DEPARTMENT OF PARKS AND COMMUNITY SERVICES

Subject: Greaves Vacation Replat (VR243)

The Parks and Community Services Department has reviewed the Greaves Vacation Replat application and is submitting the following preliminary comments on behalf of El Paso County Parks. This application, along with the following comments and recommendations, will be presented to the El Paso County Park Advisory Board on June 12th, 2024:

# GREAVES SUBDIVISION FILING NO. 1

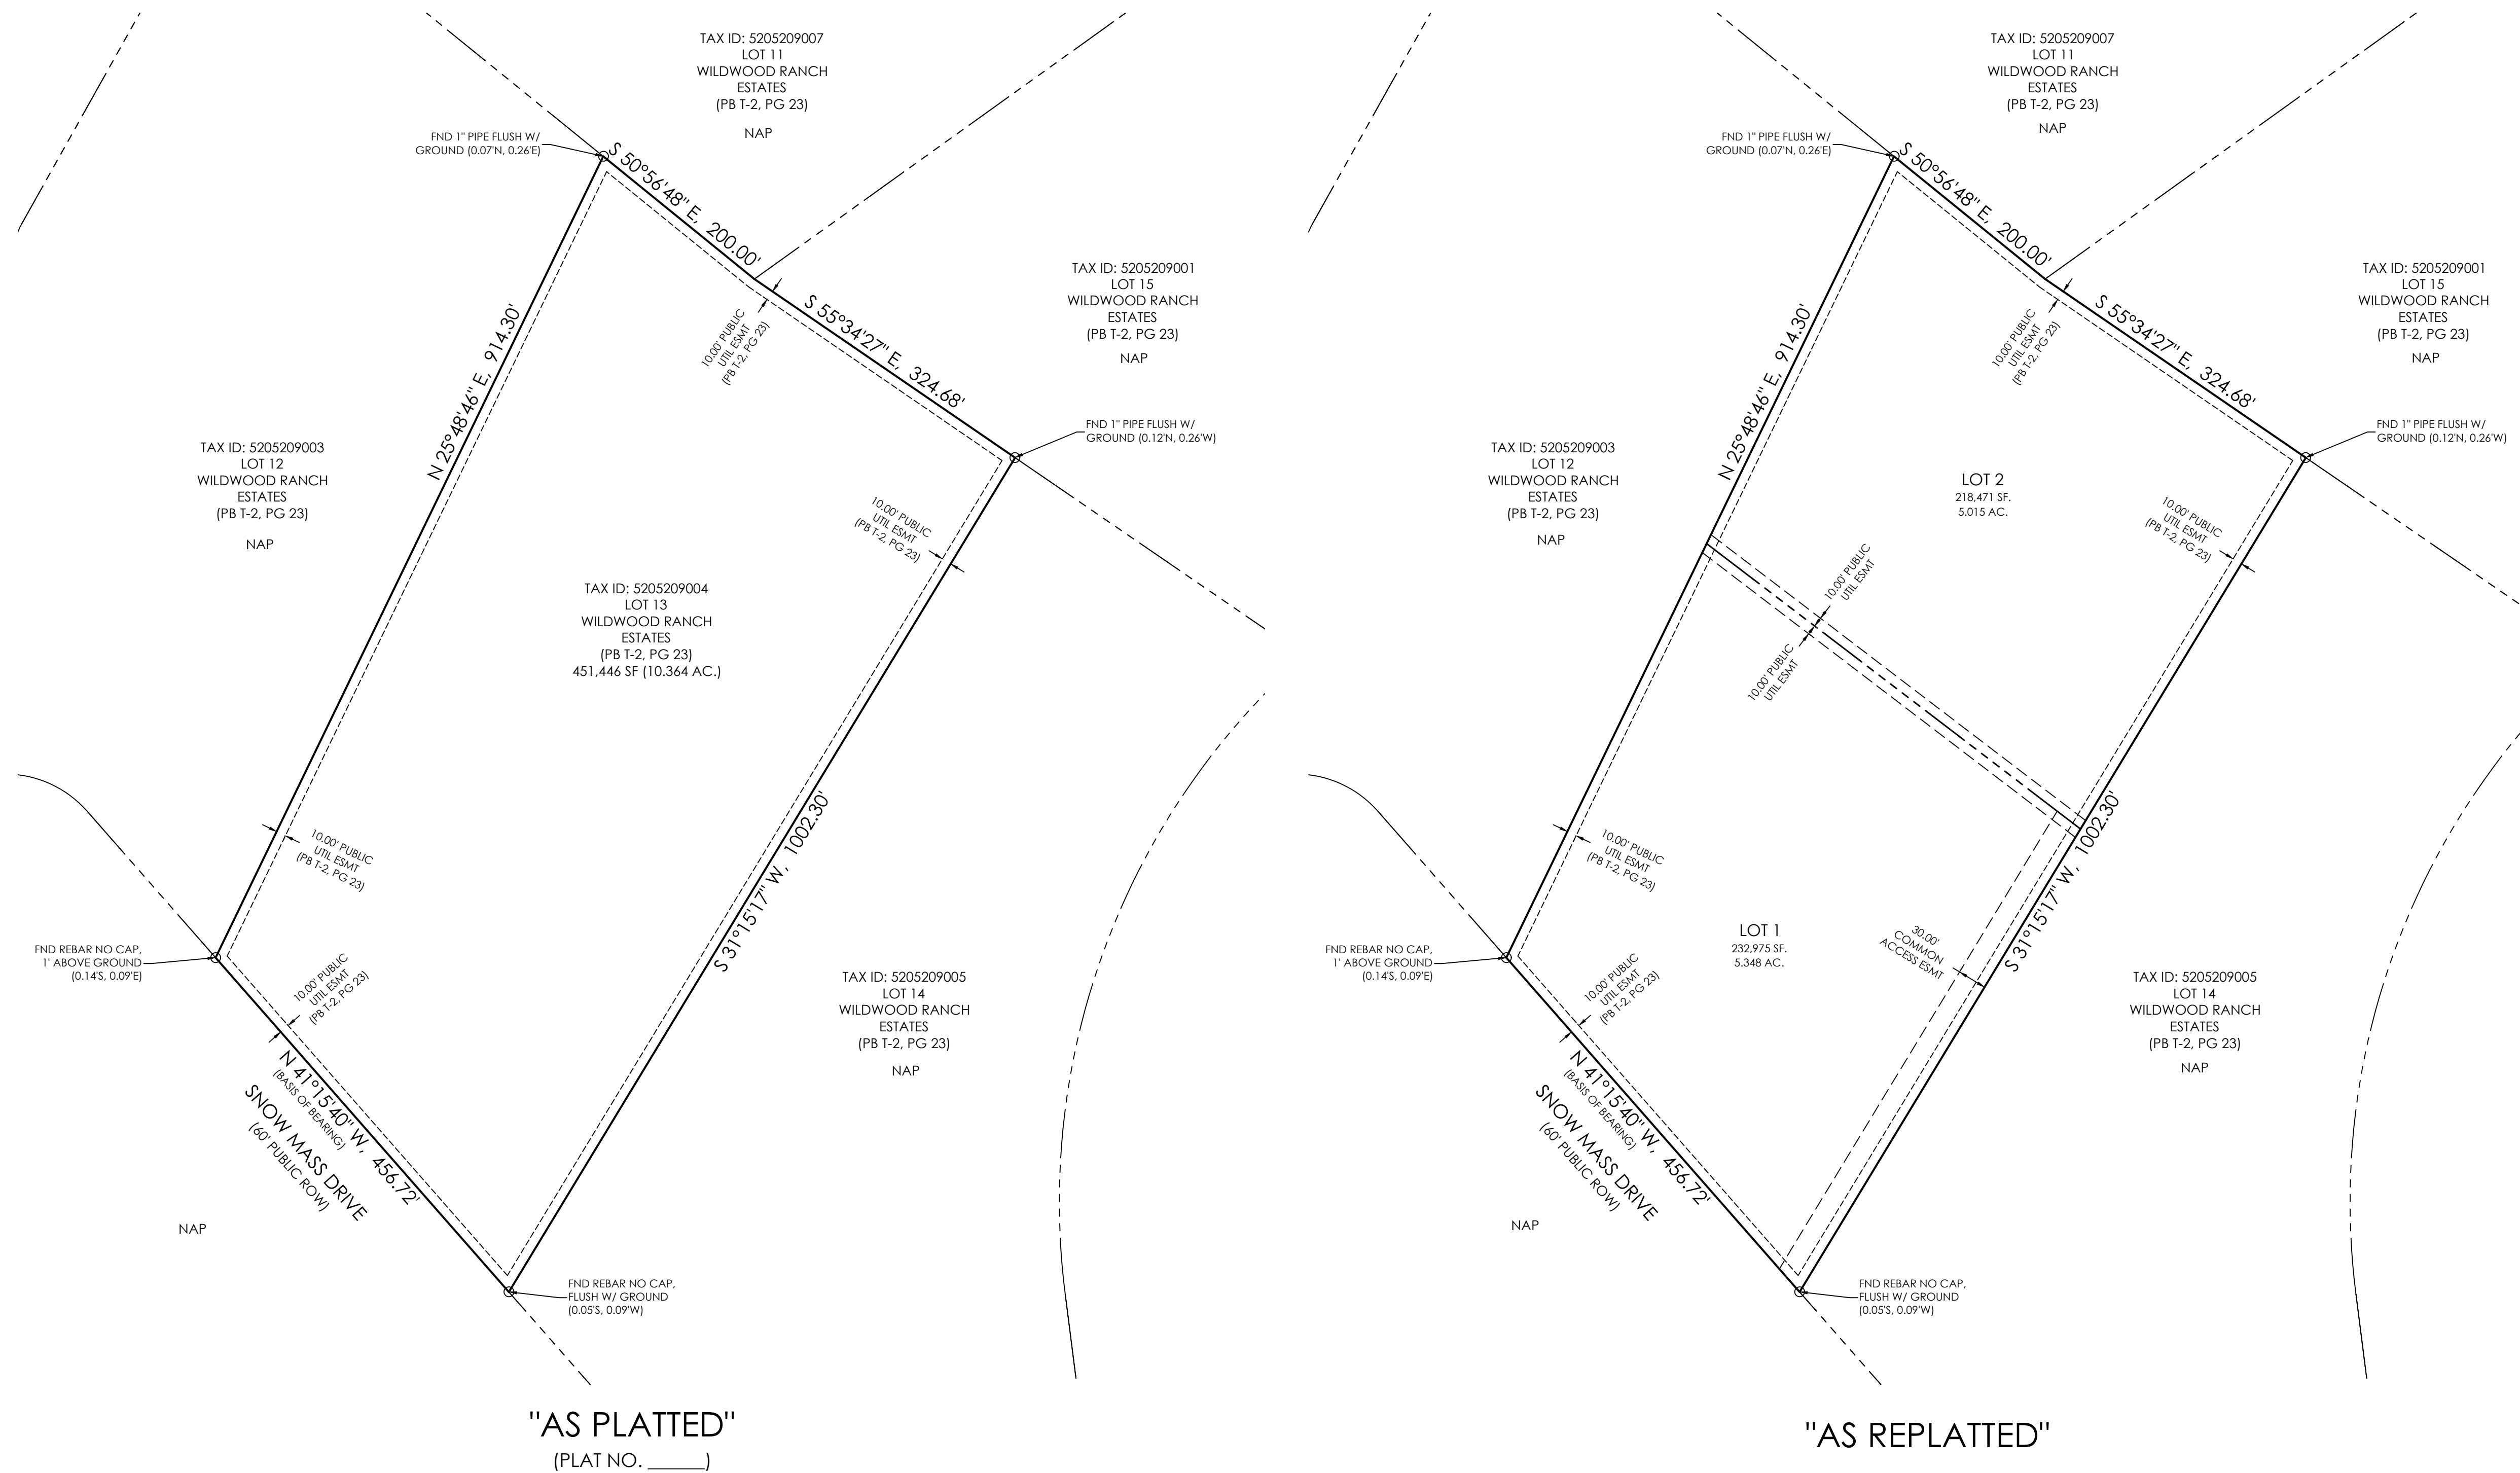
The 2022 El Paso County Parks Master Plan shows one master-planned county trail being impacted by this application. The Palmer Divide Primary Regional Trail is located along Snow Mass Drive, which will provide a connection between Black Forest Regional Park and Pineries Open Space. Consistent with LDC requirements, County Parks will require trail easements where proposed projects impact county trails. For this application, a 25-ft wide public trail easement will be sought along the southern boundary of the site along Snow Mass Dive to allow for the future construction and public use of the trail.

The Park Advisory Board recommends that the Planning Commission and the Board of County Commissioners include the following conditions when considering and/or approving The Estates at Cathedral Pines Final Plat: (1) require fees in lieu of land dedication for regional park purposes in the amount of \$920 be due at recording of the final plat; (2) show on the final plat and dedicate to El Paso County a 25-foot trail easement, along the southern boundary of the site parallel to Snow Mass Drive.
